From: Andrew Wood
Sent: 12 February 2019 09:47
To: Planning.Responses
Subject: FW: 5 CENTRAL DRIVE, MIDDLETON ON SEA PLANNING APPLICATION - ADC REF: M/155/18/PL
Attachments: 190211 5 Central Drive Elevations + Street Scene.pdf

Subject: 5 CENTRAL DRIVE, MIDDLETON ON SEA PLANNING APPLICATION - ADC REF: M/155/18/PL

PROJECT TITLE Proposed development at 5 Central Drive	DRAWING TITLE Proposed Elevations		No	REVISION	DATE
	STATUS Planning Application				
	SCALE 1:100 @ A3	DATE 14.12.2018			
	DRAWN BY AP	DRAWING No PA-270-07

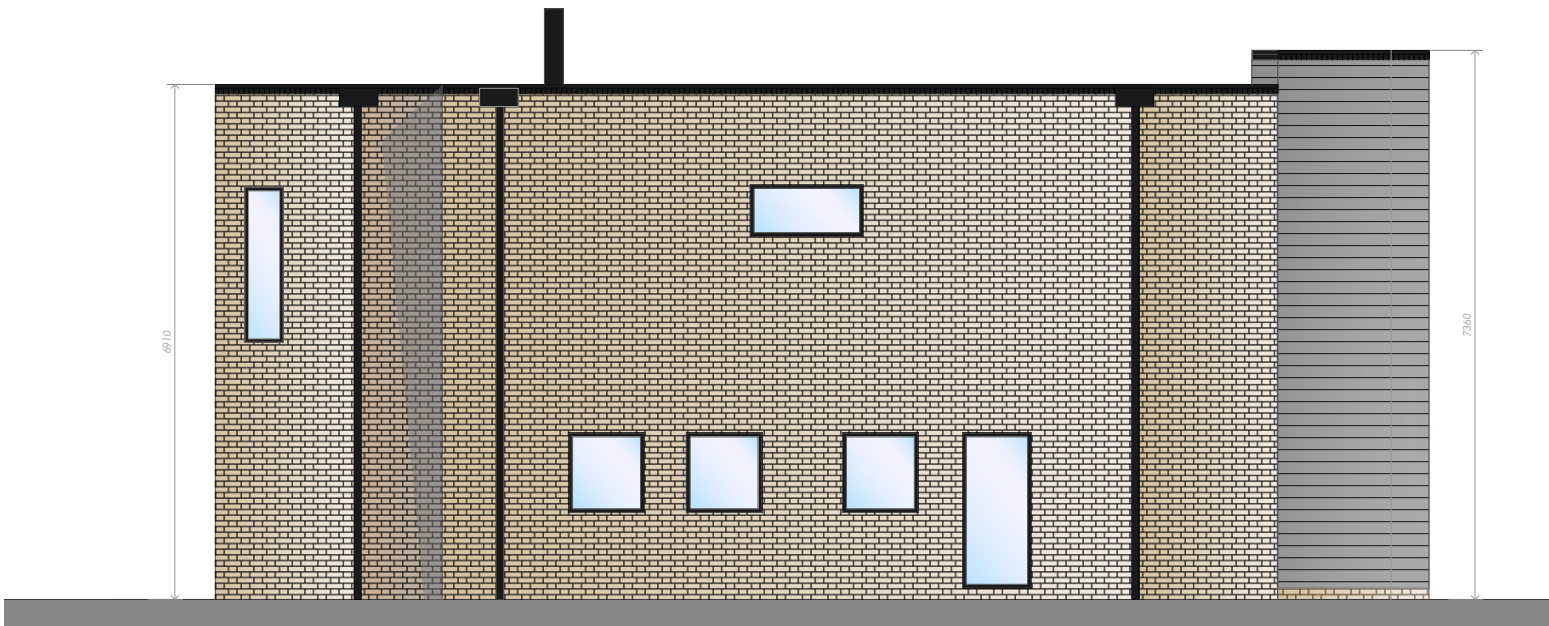
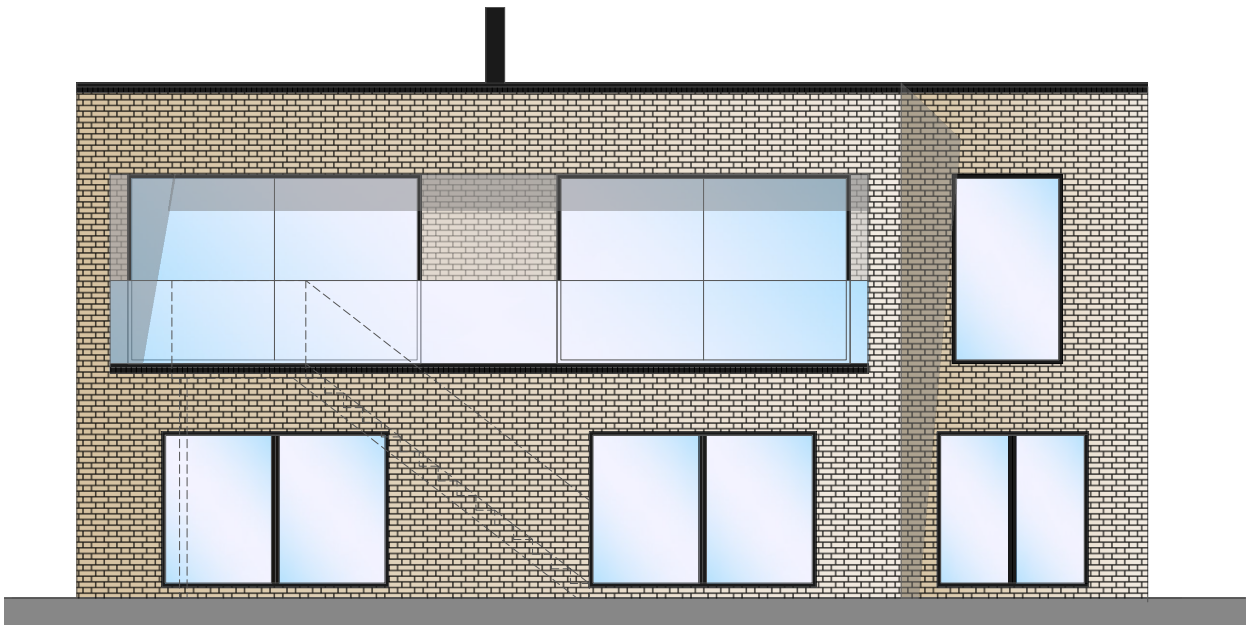
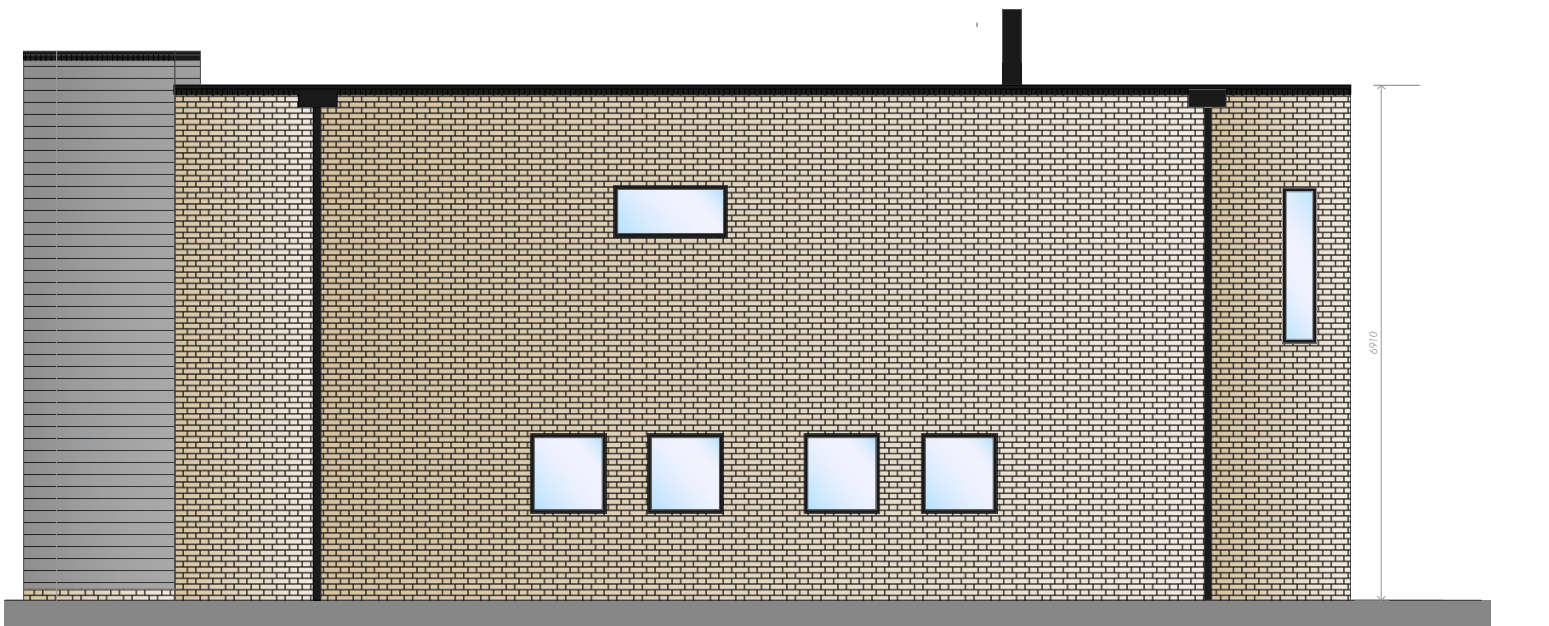
Given the samples you have provided I would suggest providing almost photographic elevations as the materials you have shown are really quite light and I would advise this is demonstrated in the strip elevations (and ideally in a further update to the primary elevation drawings) as I believe that this will be a key consideration as to whether or not the built form will be viewed as 'overbearing'.

Mark, is this the true colour of the brick? If it is lighter I would show that however I will accept the one you have just sent if you do not send a further brick.

Could you also provide a re-coloured strip elevation?

It is worth demonstrating that the proposal will lighten up the street scene in particular with respect to the dwellings opposite on Central Drive which at 15/16 metres away are a little substandard given they are primary facing elevations.

Do have a specification of the brick and weatherboarding you are proposing to use ?

Please find attached a set of the elevations with the description changed for the facing brick to match that of the manufacturer. These plans do not have a revision letter, but will now supersede the last plans we issued. Thanks,

The brick is Vandersanden 'Ledbury' Please see an array of images attached of the brick used on modern buildings, which can be used in support of the application.

The cladding will be a larch which will start as a warm golden colour and eventually weathering to a greyish colour, very similar to a beach groyne. We have attached images of 'before' and 'after' as it were!

Please see attached a set of revised elevations with lighter hatching for the brickwork. This reflects a little better the proposed sandy brick.
